Case Officer: Linda Griffiths

Applicant: David Green, Barratt Homes

Proposal: Discharge of schedule 2 clause 3.7 of 15/01326/OUT - , Bridleway Scheme, Bridleway Specification and the Management Plan

DATE: 13th October 2021

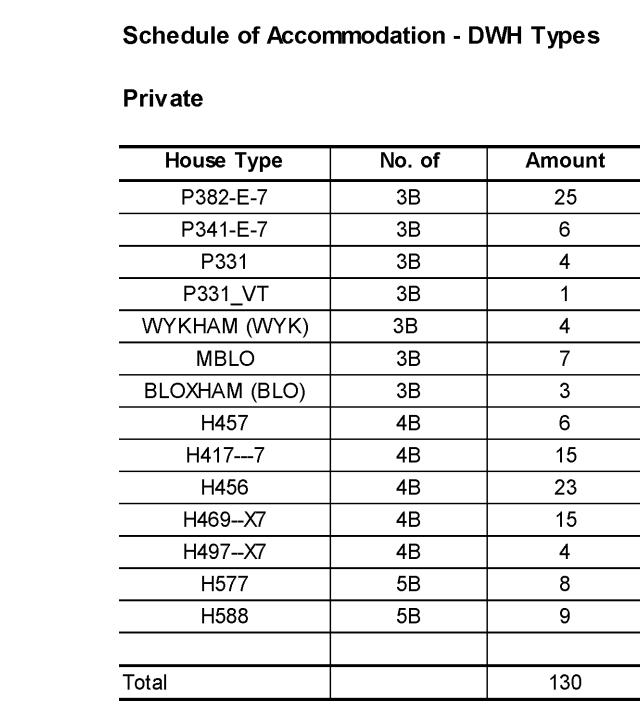
5.2 CDC - Landscape Officer – a self-binding gravel needs to be laid on hardcore. A sample of the self-binding gravel should be submitted for approval. Open spaces, car park and bridleway management plan are acceptable.

- The specification does not mention space either side of the bridleway, 3m is narrow, 4m is preferred;
- No detail provided of the crossing point over the spine road;
- Pinch point around the edge of the adult football field, use by equestrians during a football game could be challenging;
- The maintenance regime does not specifically mention grass mowing and cutting of vegetation adjacent to the bridleway. Although probably picked up elsewhere, it should be included as a requirement of the bridleway maintenance.

7.3 In terms of the above, the applicant was requested to re-consider the submission. It should also be noted that the route of the bridleway as shown in this submission is as shown in the reserved matters, which is approved. The applicant was asked to consider re-routing the bridleway to the north of the sports pitches closer to the development, but was not accepted. This route would not be ideal either in terms of its relationship with the pitches or the residential development itself. It is therefore considered that the route shown is preferable and whilst its proximity to the pitches could on match days be a challenge, OCC have not stated that it would be unacceptable. The submission is therefore accepted in this instance. In terms of the management of the open space adjacent to the bridleway, this is addressed in the Open Space Management Scheme. The crossing of the bridleway over the spine road has already been approved as part of the reserved matters submission.

That clause 3.7 relating to the bridleway be discharged, in accordance with the Bridleway Specification and Scheme dated June 2020 Rev P3.
